Redlines to correct TPAs - 3/16/2020
Chris Cune

8. Existing and Proposed Lot Information

(X) This BLA meets the requirements of Kittitas County Code (Ch. 16.08.055).

SHEET 1 OF 3

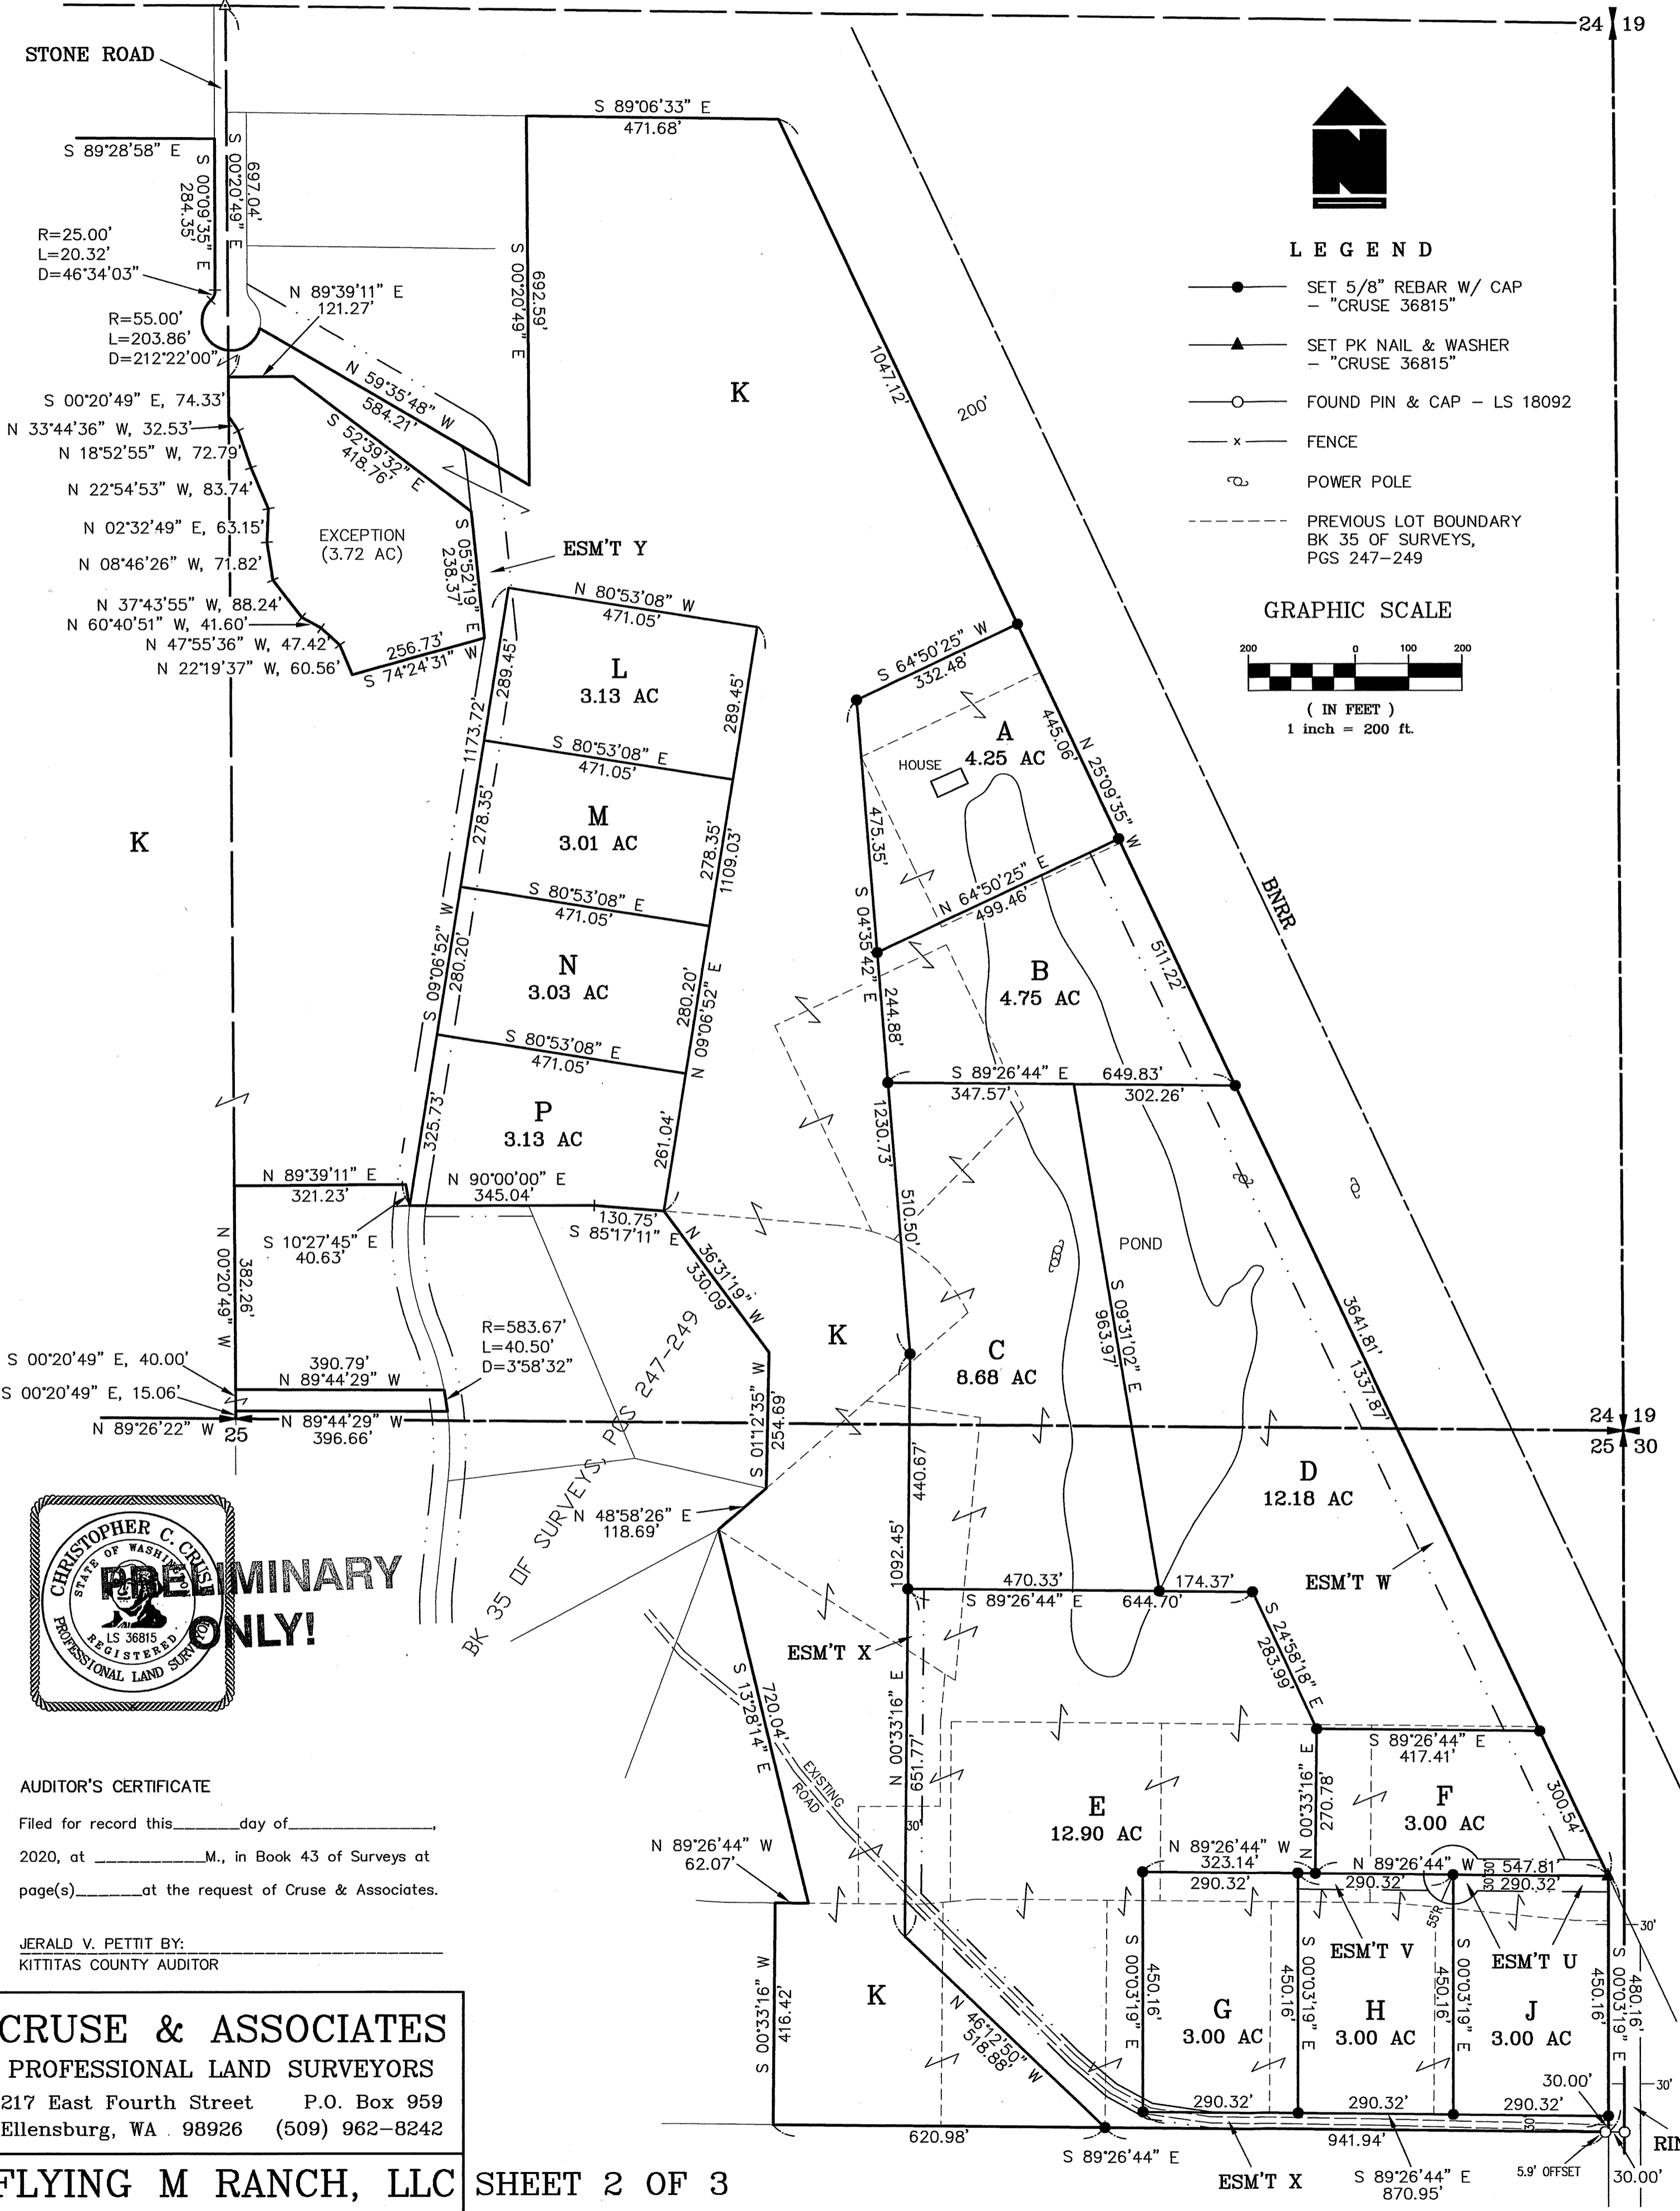
9.44 AC (C) 8.68 after review

~~12.86 AC (D)~~ 12.18

Adjusted to match OTHER final Survey

No Lot 'I'
 to match
 final Survey
 Chris Cruse
 12/8/2020

3.13Ac (L) Lots of Survey
3.01Ac (M) to be recorded
3.01Ac (N) after review
~~3.03Ac (P)~~ 3.13 - Adjusted to
match final
